From: Michael Eastham
Sent: 01 April 2019 15:45
To: Karen Parsons
Cc: 'Laura Humphries'; Laura Gibbons
Subject: FW: Ashdown Vale, Lake Lane, Barnham - BN/59/18/DOC

From: Paul Cann
Sent: 20 March 2019 14:07
To: [REDACTED]
Cc: Laura Gibbons; Michael Eastham
Subject: Development at Lake Lane, Barnham

Ditch Filling Detail

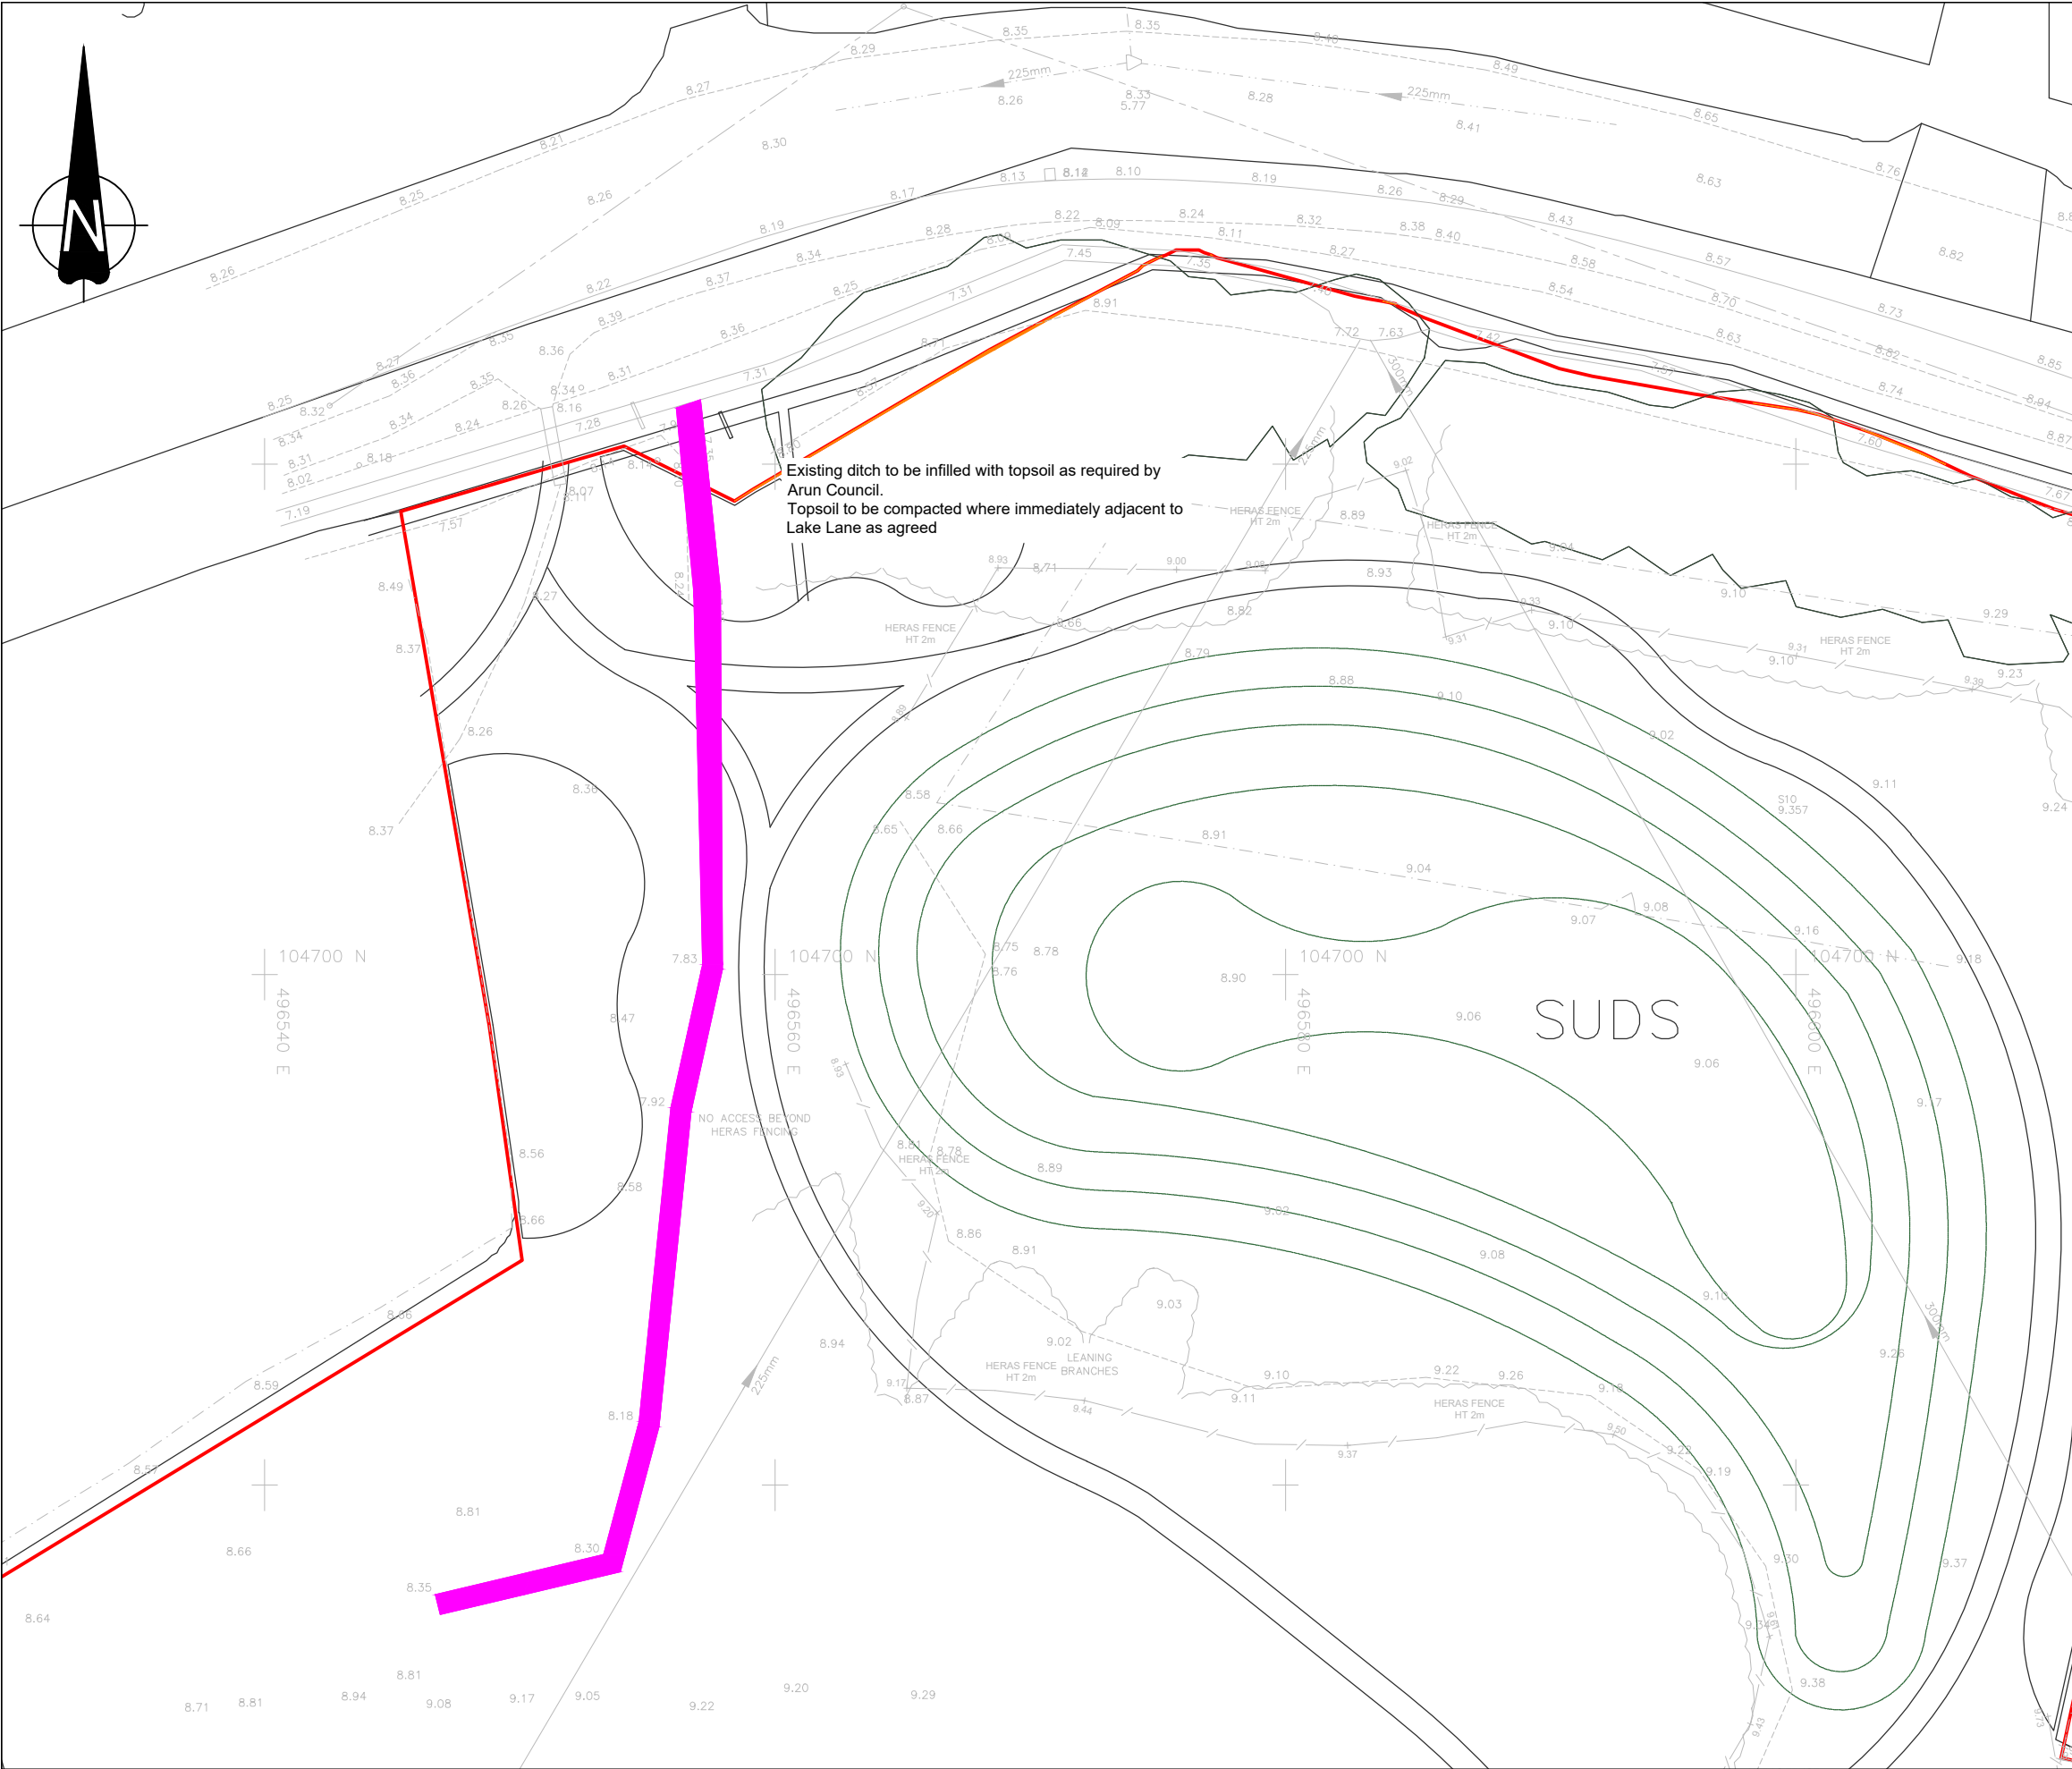
1. Has been infilled but not in accordance with the approved drawing. I.e. it was to be filled with topsoil but has been filled with hardcore, etc. As a compromise, we are willing to accept the situation on the proviso that topsoil is placed over the top (say min. 200mm thick).
